Office of Environment & Heritage

RE: Major Project MP08_0046 – Part 3A - to Expand d'Albora Marina, Western Side of Spit Road, The Spit, Mosman

Attachment A Comment on the Proposed Expansion of d'Albora Marina

11 Attachment B – Slipway Detailed Design

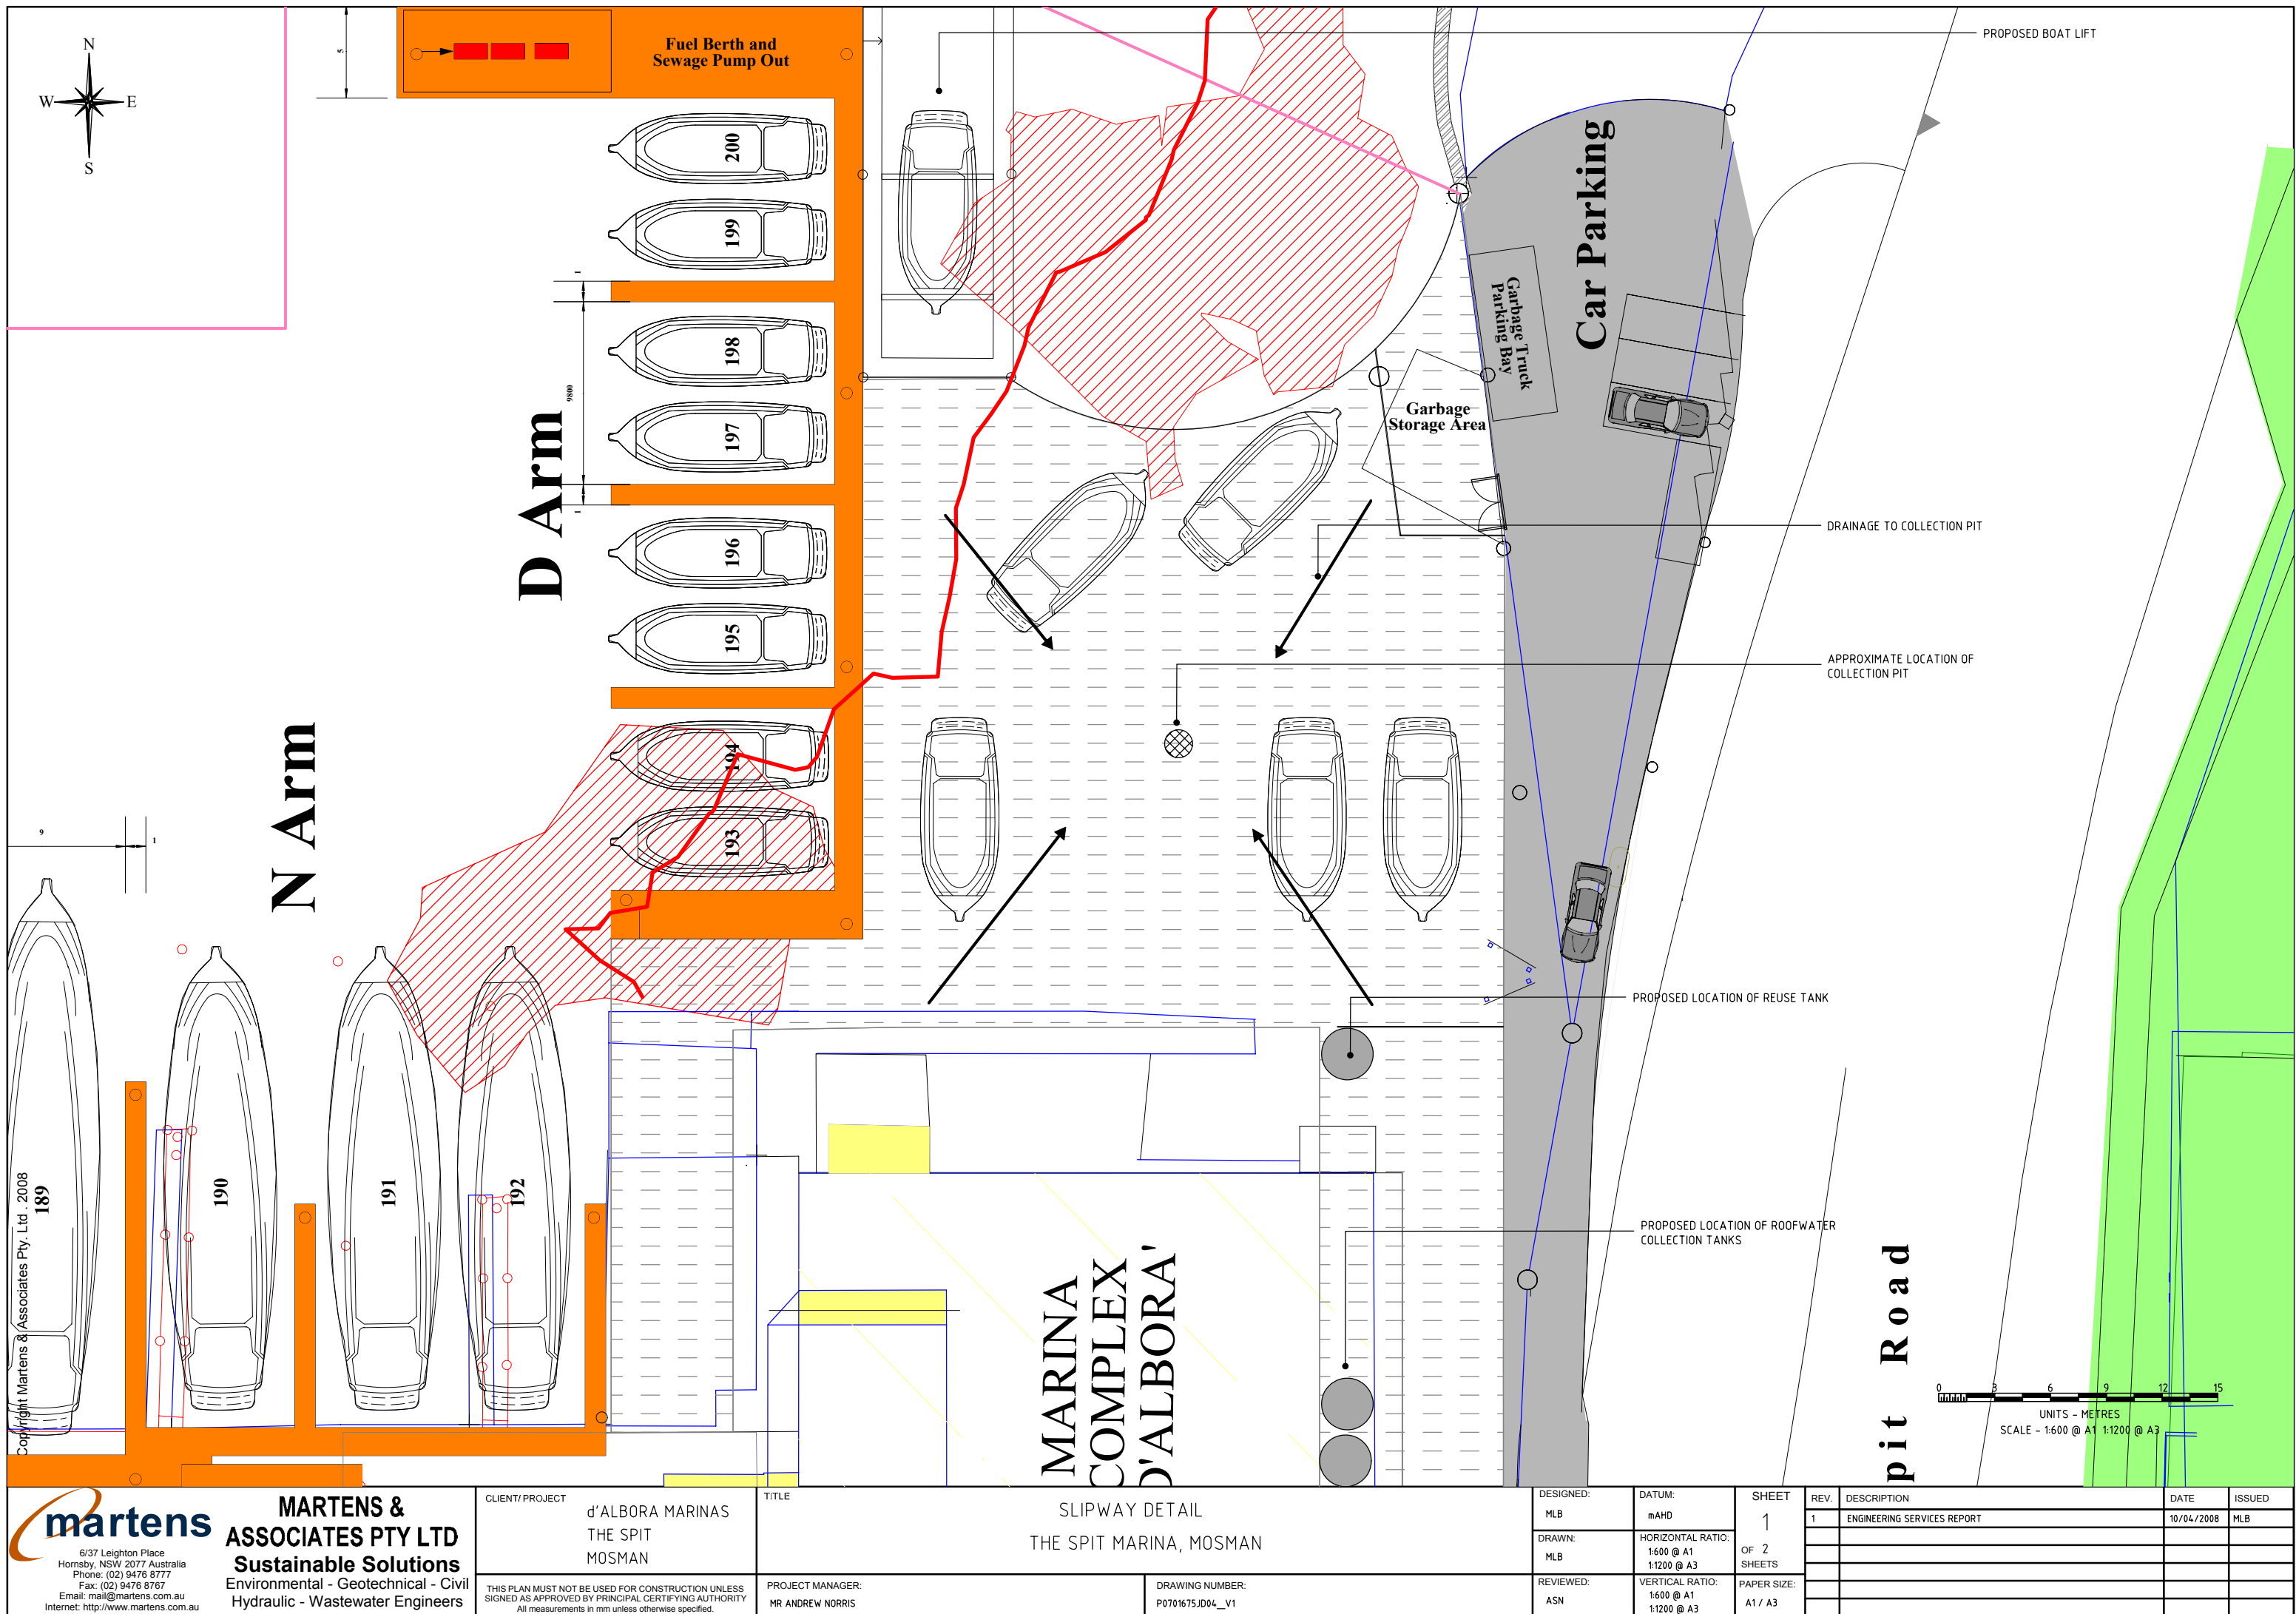
The main issue of concern is that if the slipway is used during wet weather potentially contaminated waste material generated whilst boats are being worked on would enter the stormwater system/Middle Harbour (thus polluting waters) when the system reaches its design capacity and is bypassing to stormwater system/bay. It should be noted a first flush system is only appropriate when first flush is not used during wet weather.

To address the above the proponent needs to provide the design specification and layout drawings of the first flush system and the stormwater bypass mechanism. In addition the proponent must also provide detailed explanation on how they are going to prevent contaminated rainwater entering the stormwater system/Middle Harbour if they intend to use the slipway during wet weather.
